Application No.: 22/03350/SCOP

Proposal: Scoping opinion - In accordance with Regulation 15 of the Town and Country Planning (EIA) Regulations, 2017 (as amended) (the 'EIA Regulations'), seeking outline planning permission for up to 170 residential homes (Use Class C3), new play facilities, public open space, landscaping and vehicular access from the B4100 Warwick Road on Land East of Warwick Road, Banbury

Location: Land East of Warwick Road Drayton
Warwick Road
Banbury

**TITLE:**  
PROPOSED VEHICULAR ACCESS  
OPTION 1 (50MPH)

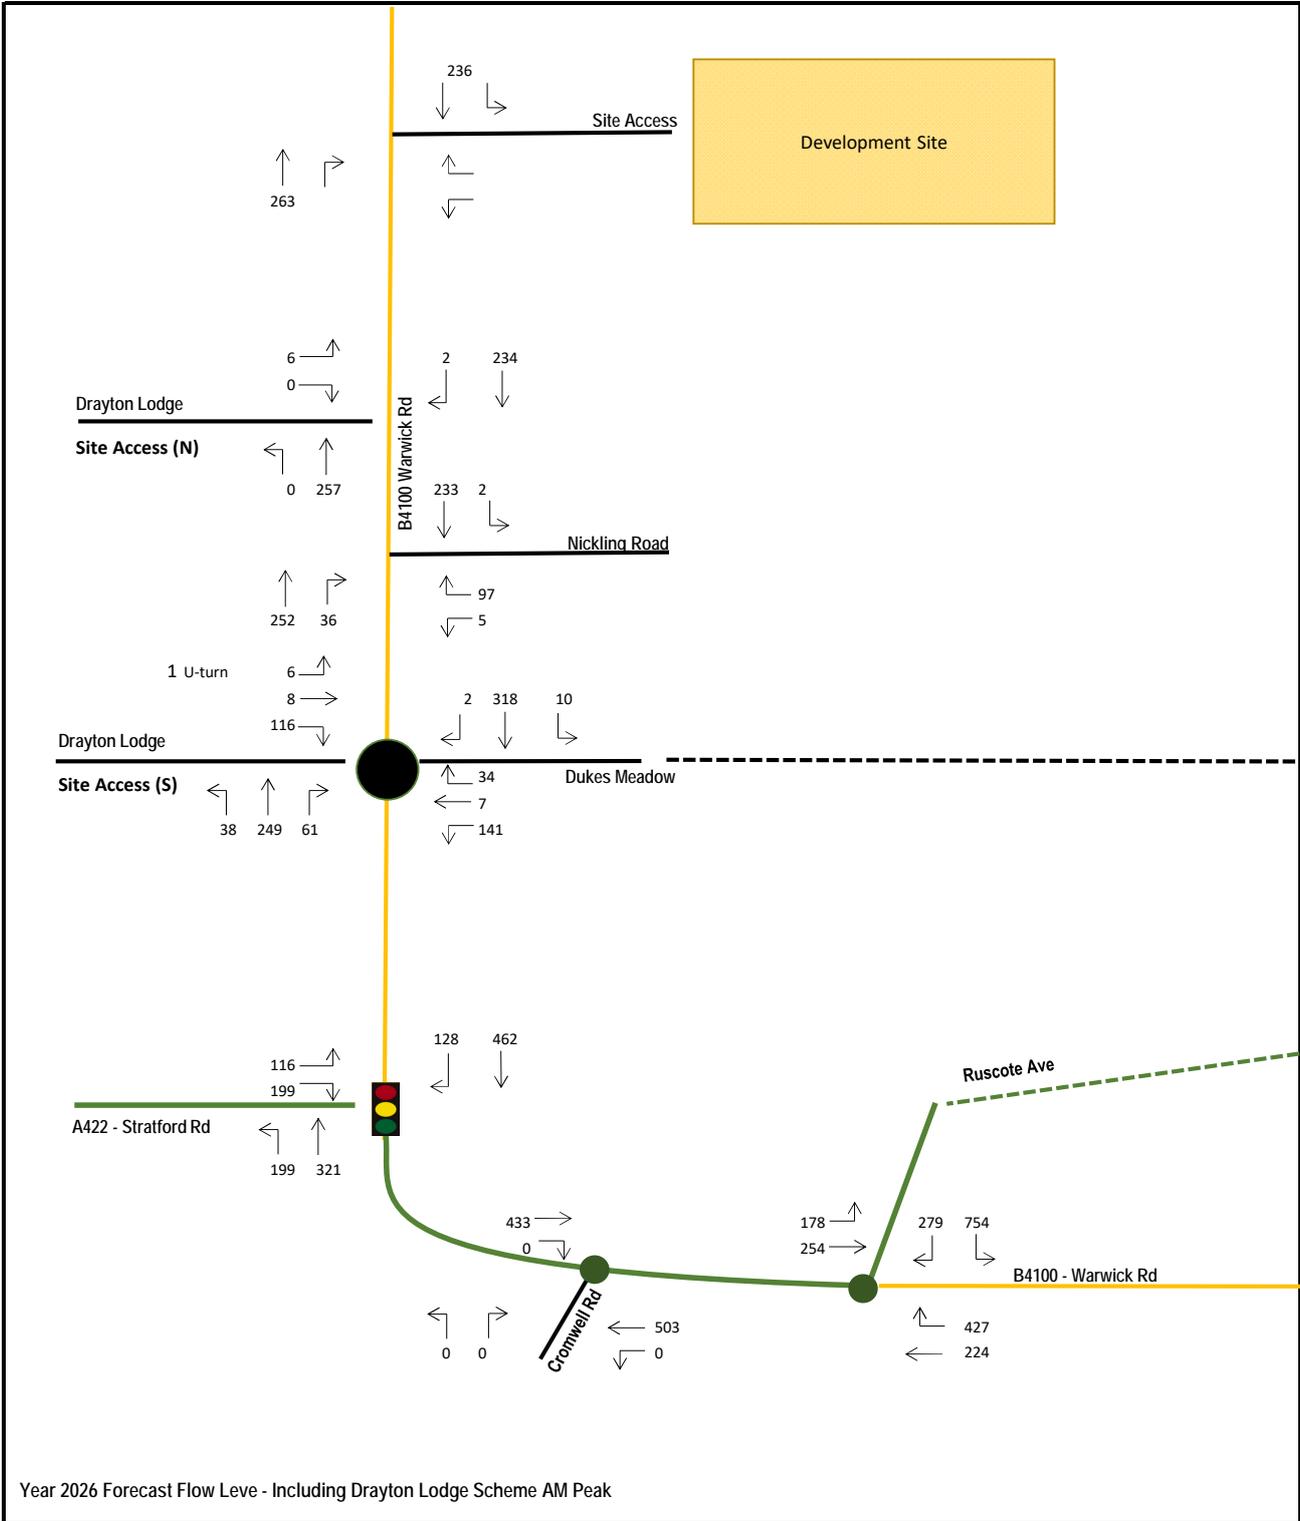
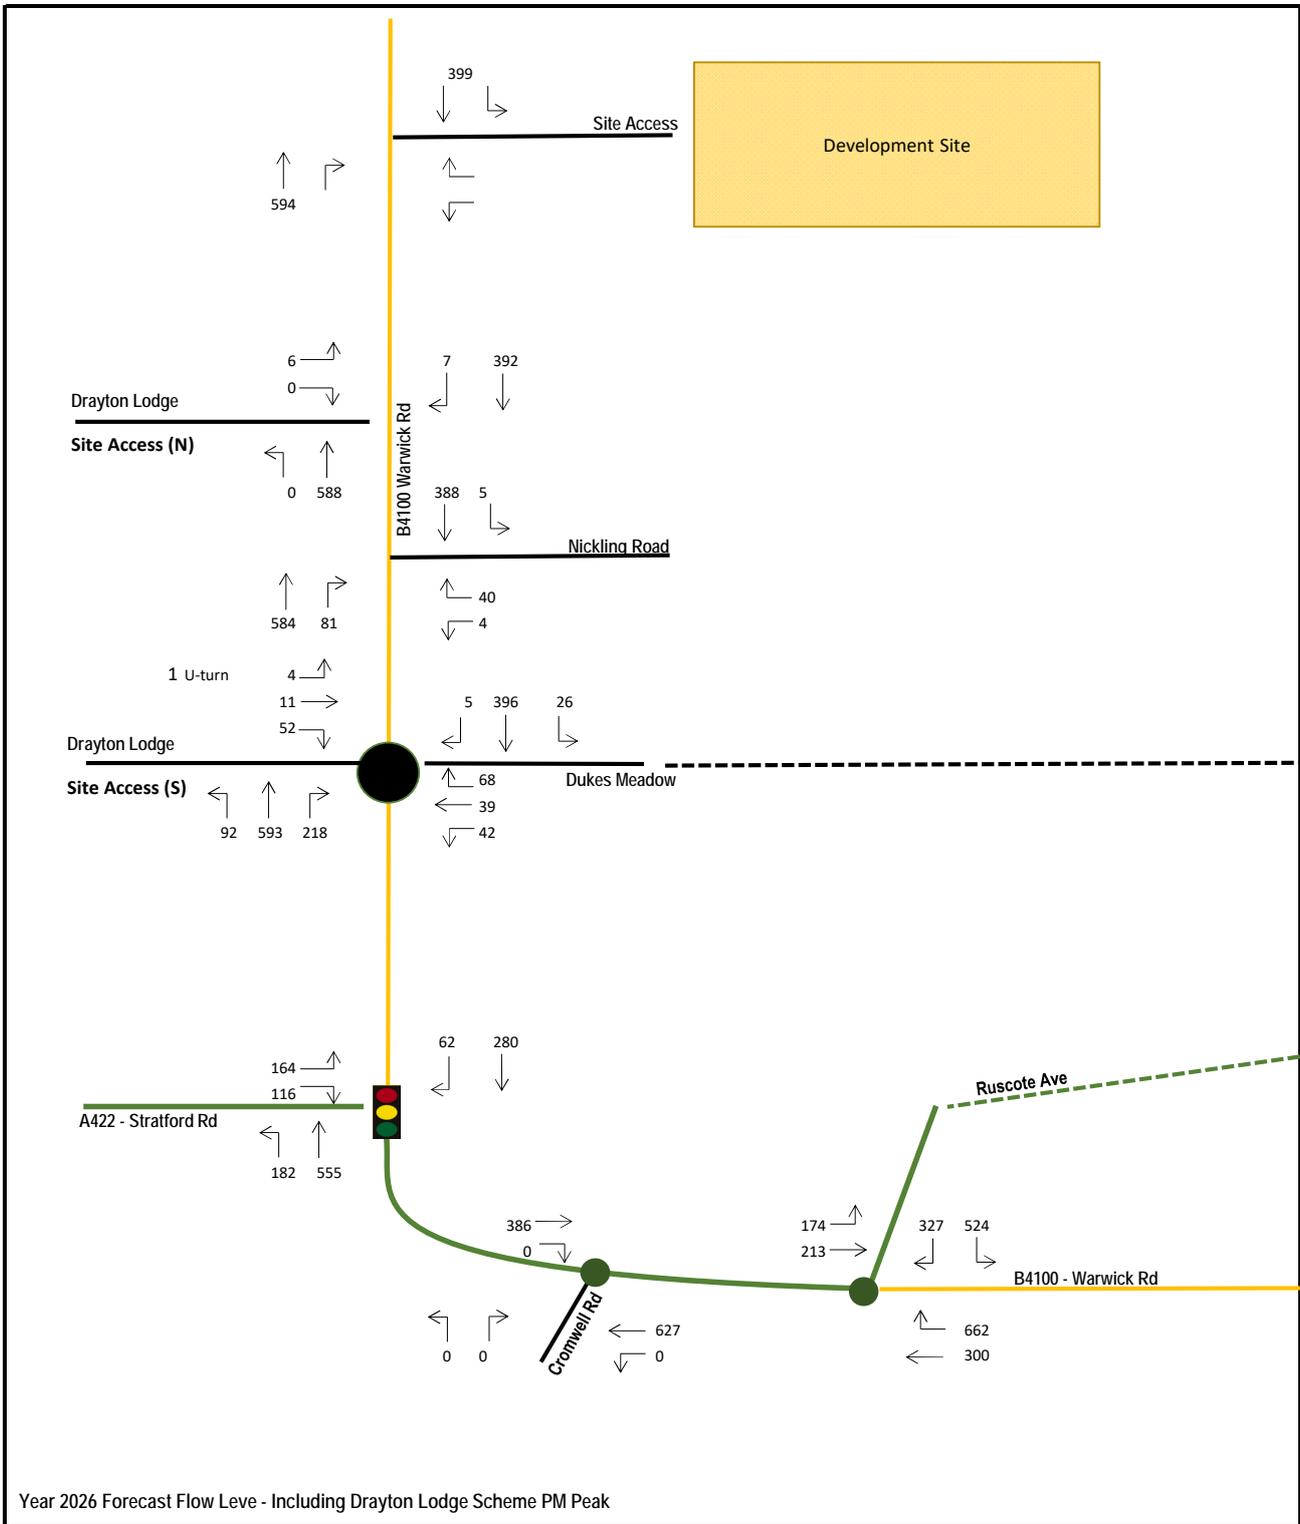
Driver Delay has been appraised by junction capacity tests that have been carried out at 'identified junctions', including the access junction. Whilst this approach is acceptable, without details of the proposed access junction it is not possible to review this exercise.
